Recommendation Report for Planning Permission for Works or Extension to a Dwelling

REF NO: AB/36/19/HH

LOCATION: 44 Fitzalan Road
Arundel
BN18 9JS

PROPOSAL: Rear single storey orangery extension to replace the existing conservatory.

PLANS & ELEVATIONS OF PROPOSED ORANGERY

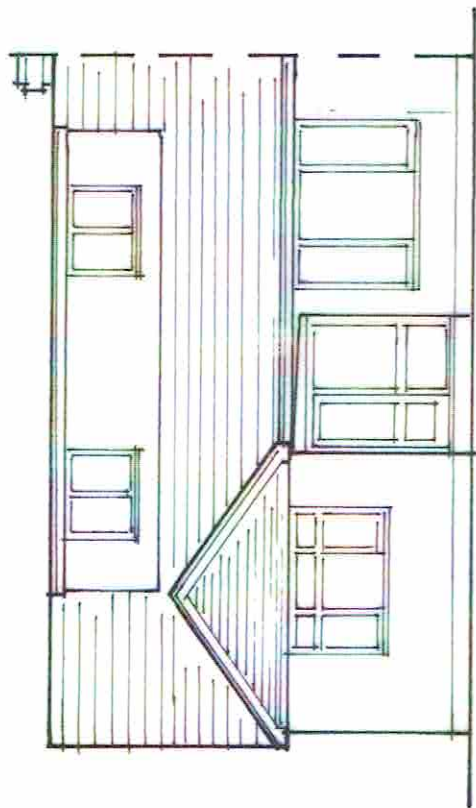
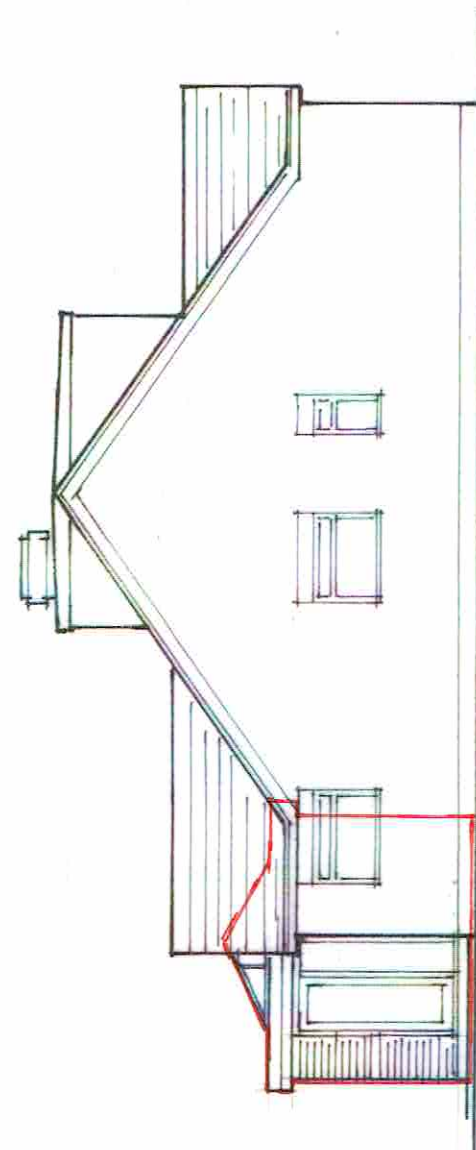
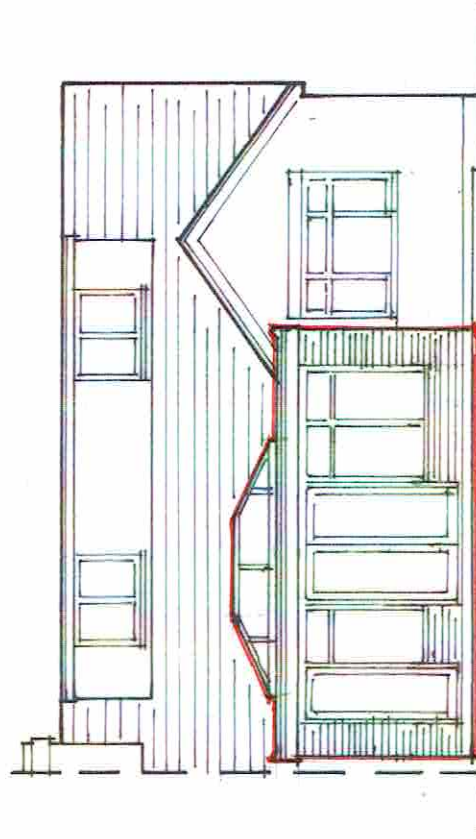
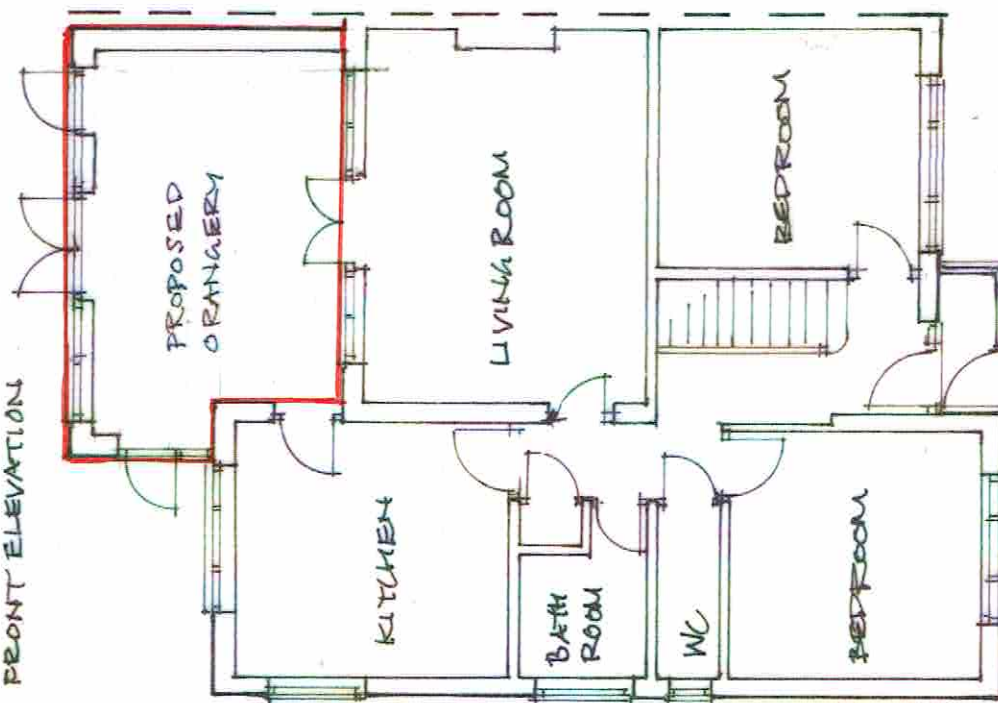
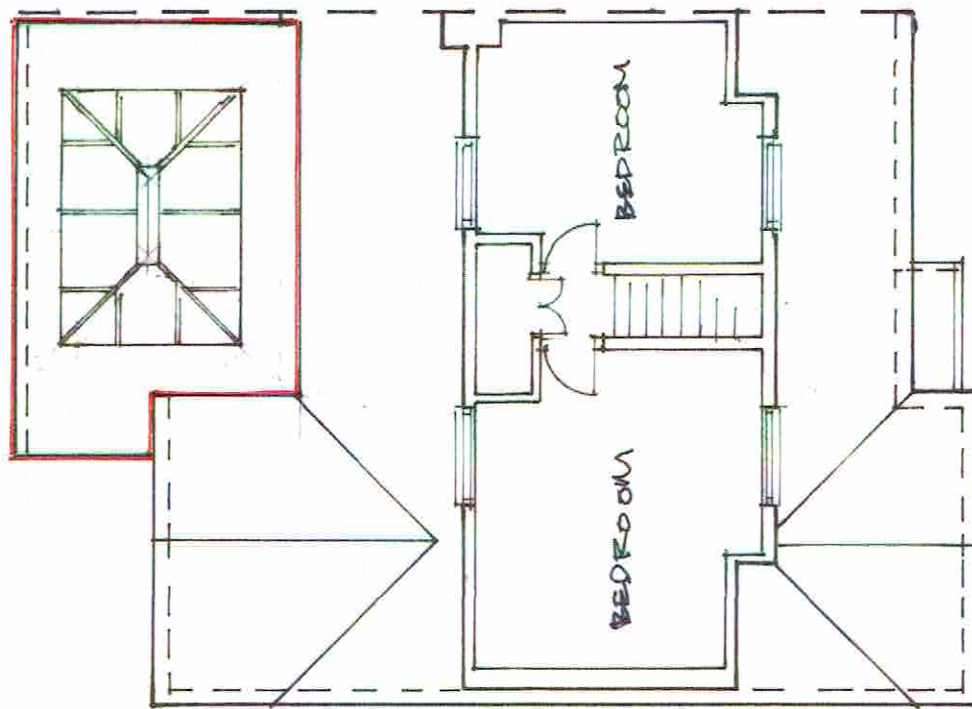
The maximum height of the proposed development is 3.4m from ground level, however, this is as a result of a roof lantern, the majority of the proposal is approximately 2.7m from ground level. This is approximately 0.2m higher than the existing rear extension. Therefore, the proposed development is considered to appear subservient, nor is it deemed to harm its established character.

The proposals maximum height is 3.4m however, this is atop of a rooflight, which is set 0.9m away from the Northern edge of the extension, the majority of the extension is 2.25m lower than the existing ridge height of the dwelling, and there is not deemed to give rise to any significant adverse impact on neighbouring residential amenity. There is not considered to be a significant loss of privacy as the proposal features no windows on its Northern elevation, and even if there were, any views would be impeded by the fencing that lies between the two properties.
